RECOMMENDATION FOR PLANNING AND DEVELOPMENT COMMITTEE

APPLICATION REF: 3/2026/0375

PROPOSED SYNTHETIC TURF PITCH, INCLUDING FENCING, ACOUSTIC BARRIER, FLOODLIGHTING, ACCESS PATH, TOILET BLOCK AND ANCILLARY EQUIPMENT AT PLAYING FIELD, EDISFORD ROAD, CLITHEROE, BB7 3LA

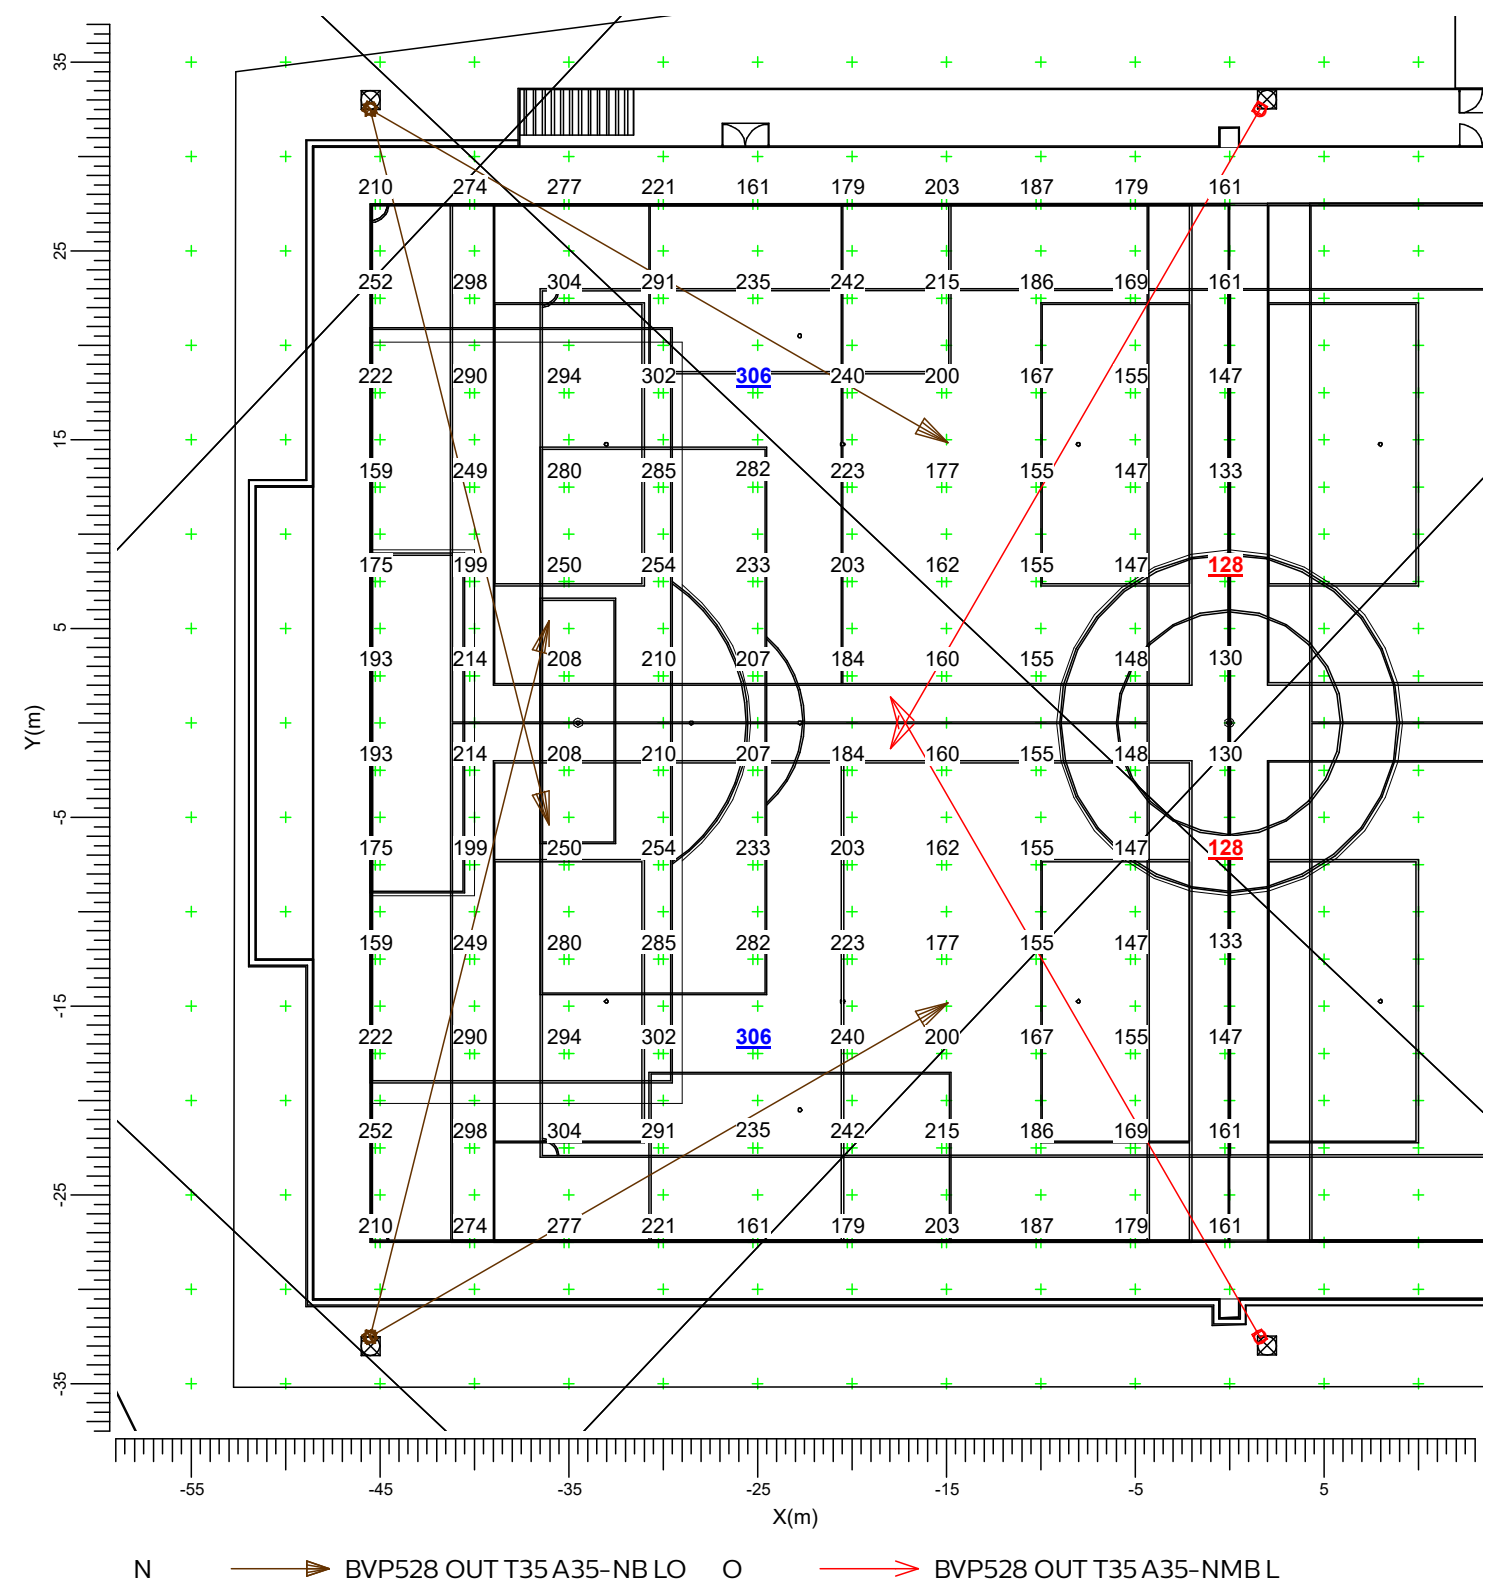
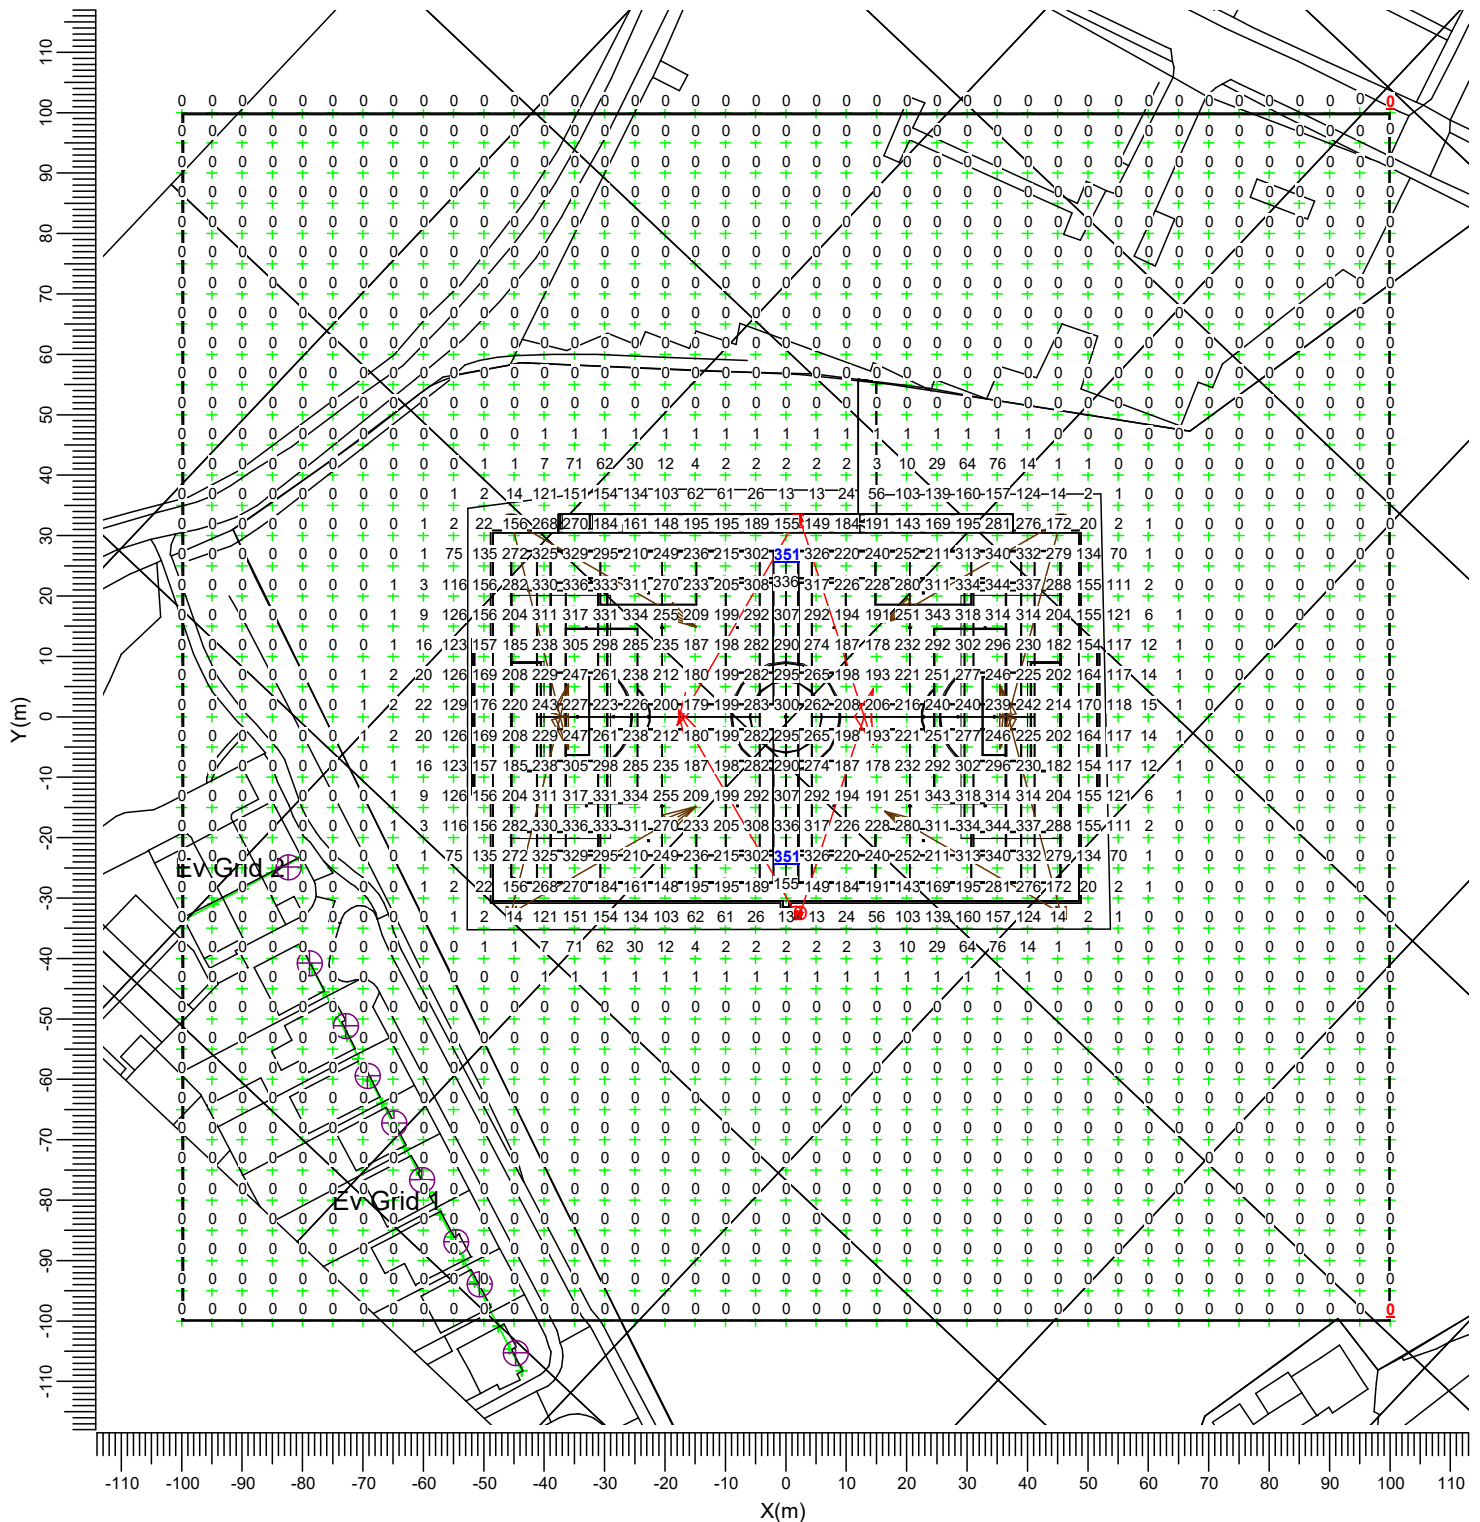
No objection on the basis of noise, subject to a number of mitigation measures being secured (operating hours and acoustic fence). Have requested further details relating to the proposed lighting scheme including clarification of the methodology used in the submitted lighting report and confirmation of the main beam angle and aiming arrangement.
